27 January 2017

**Submission regarding Global Switch Data Centre (MP 08_0222 MOD 7)
Modification Application under Section 75W of the EP&A Act 1979**

I refer to the Request to Modify a Major Project or Concept Project which is an application made by Ms Helen Mulcahy of Helen Mulcahy Urban Planning Pty Ltd. The request is for the *Modification of the approved construction hours to enable internal works to be carried out within Stage 2 of the approved development. Amend Condition A2 and insert new condition D8.1*

Figure 2 Acoustic context of the approved development (Source: Acoustic Logic)

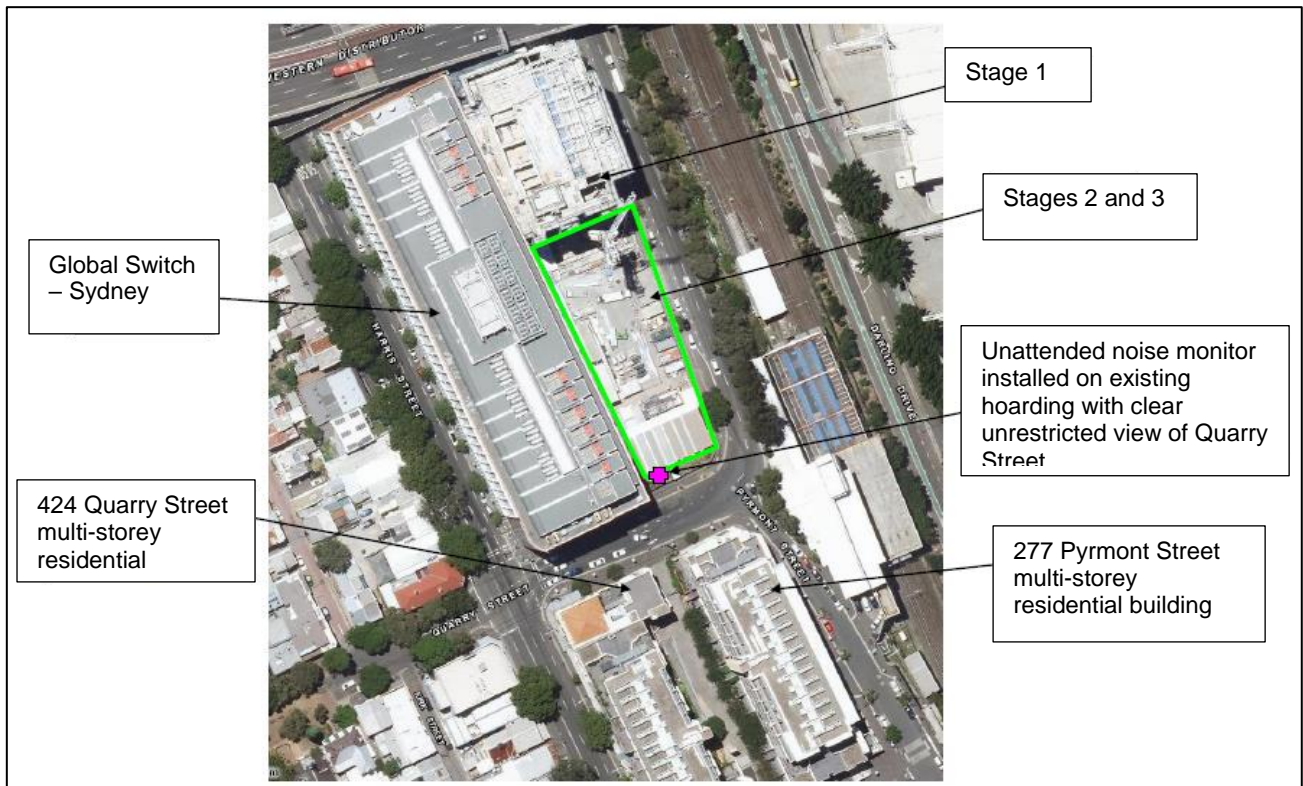
I believe the submission made by Helen Mulcahy¹ incorrectly identifies the multi-storey residential buildings. I refer to an aerial photo on page 9² where the Quarry Building is shown as “424 Quarry Street” and the Pymont Building is shown as “277 Pymont Street”. This aerial photo is attributed to Acoustic Logic.
